Rezoning Transportation Analysis

Petition Number: 2020-136

General Location Identifier: Tax ID (04308515)

Date	Description
10-23-20	First Review (EL)
11-30-20	Second Review (EL)

RZ-1.0

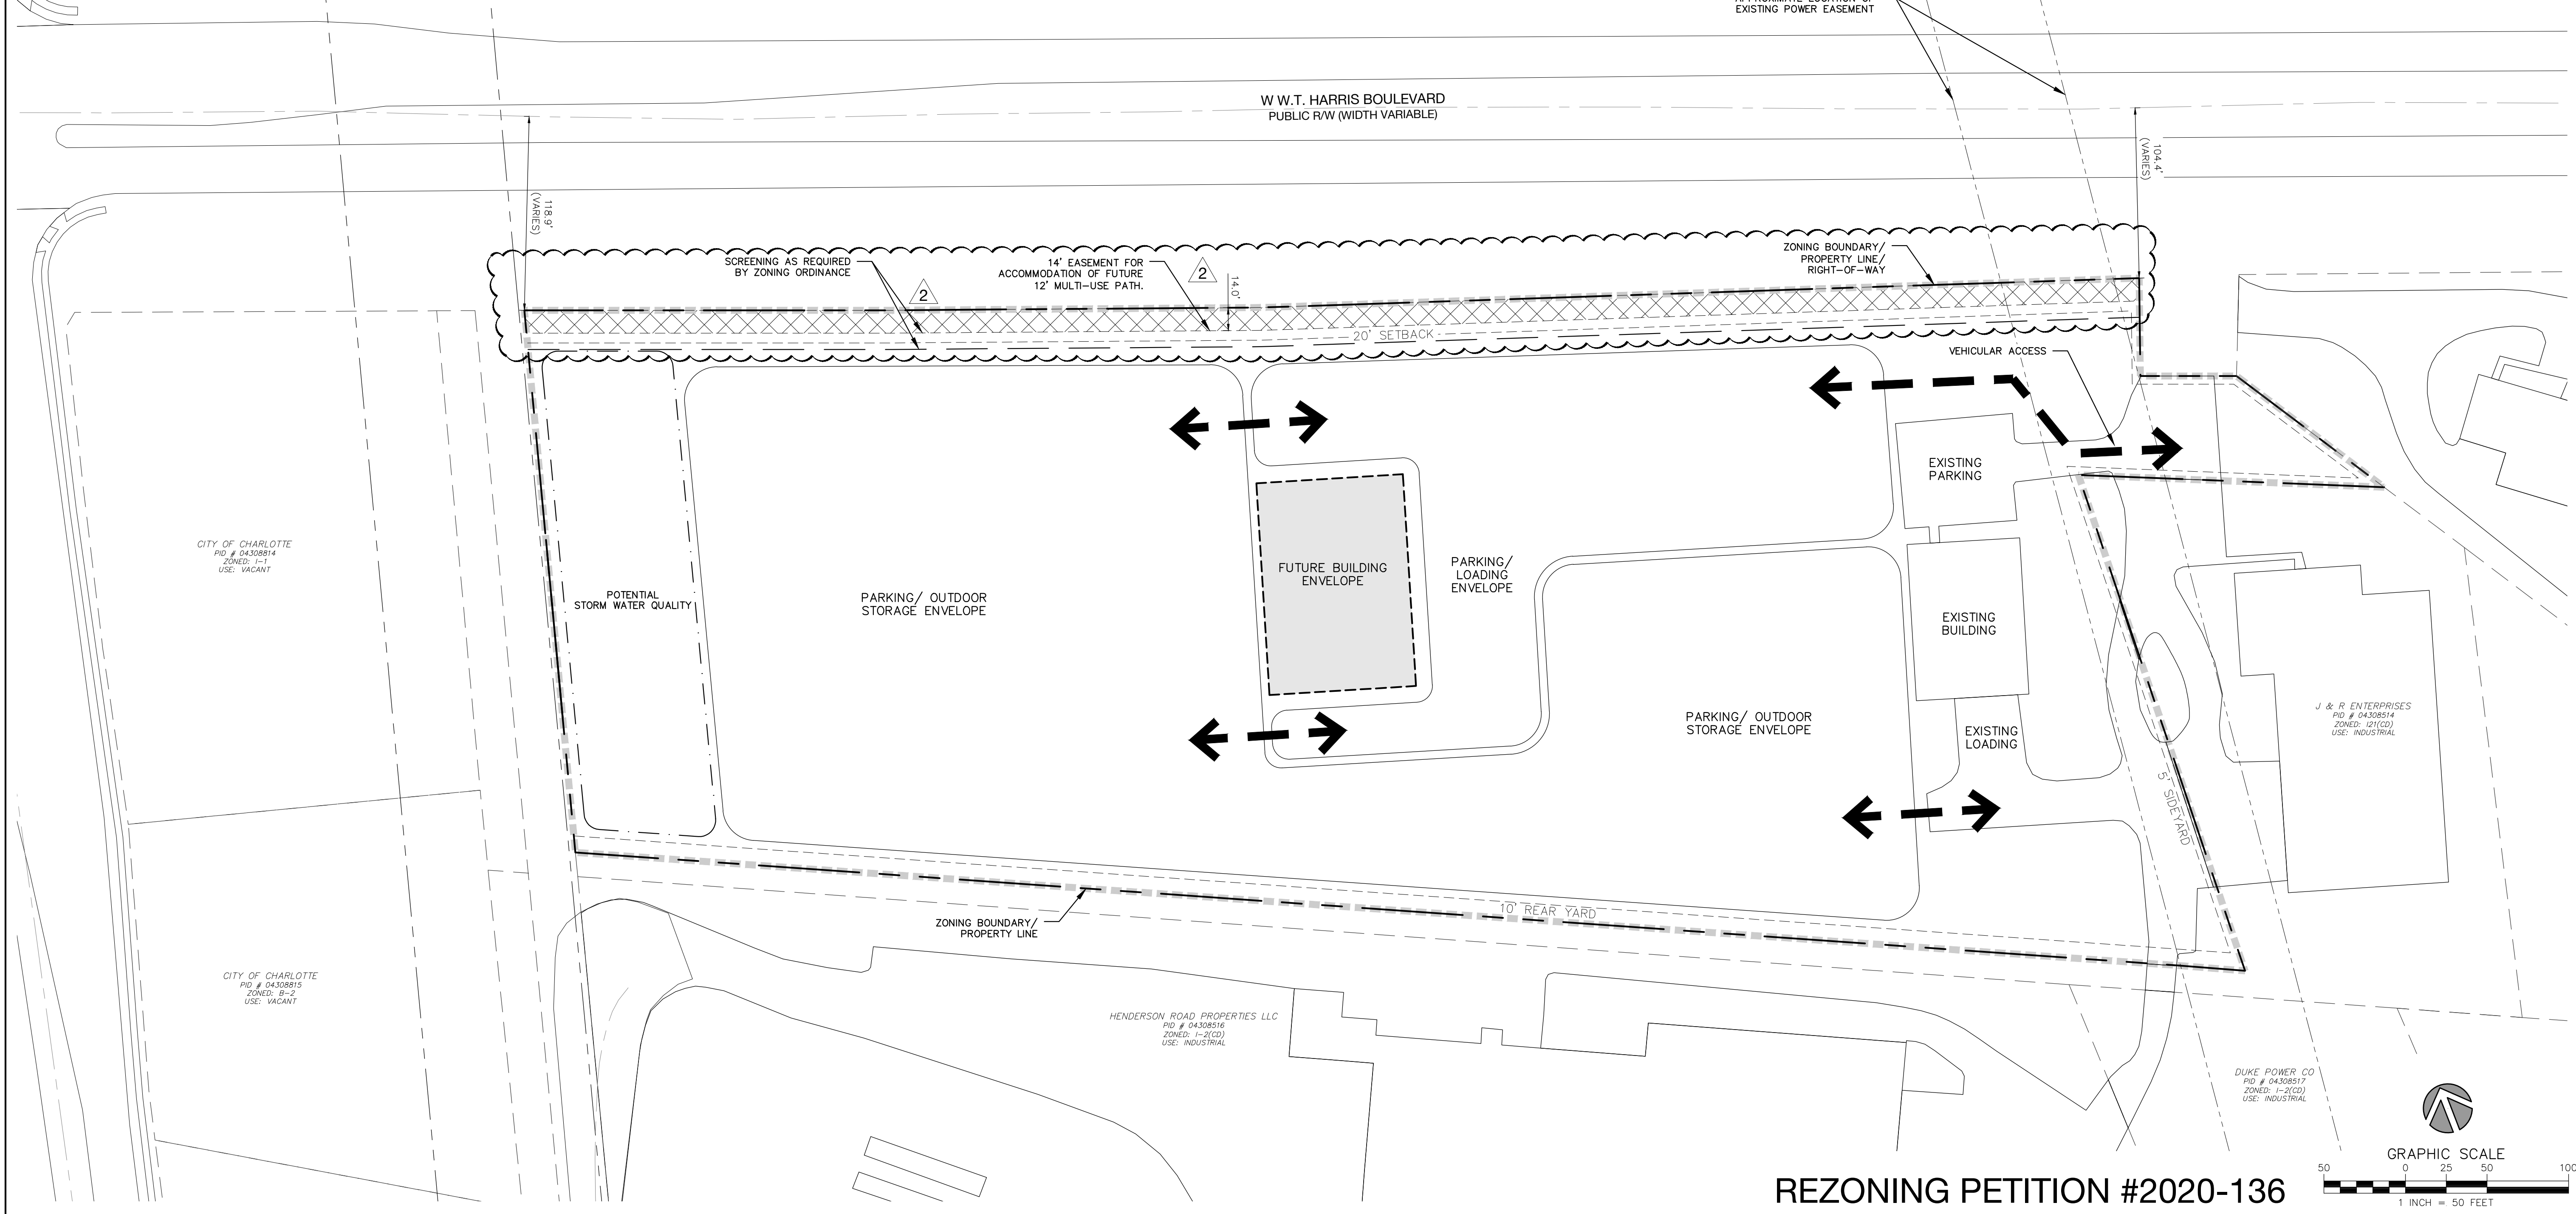
4. **Outstanding Comment (site plan dated 11.16.2020)** Site plan and conditional note(s) revisions are needed to ~~commit to construct~~ **plan for future** bicycle facilities by installing a **reserving an easement for a future** 12-foot shared-use path to meet the City of Charlotte BIKES Policy. The shared-use path needs to be installed outside of the WT Harris controlled access limits, per NCDOT, and contained within a sidewalk utility easement, installed 2-feet back of shared-use path.

7. ~~A site plan note specifying that all transportation improvements will be approved and constructed before the site's first building certificate of occupancy is issued is needed. The petitioner may phase transportation improvements if said improvements and phasing are explicitly described in site plan notes.~~
8. **New Comment (site plan dated 11.16.2020)** Conditional note **Section 4.f.** needs to be revised to remove "If required to do so by NCDOT."
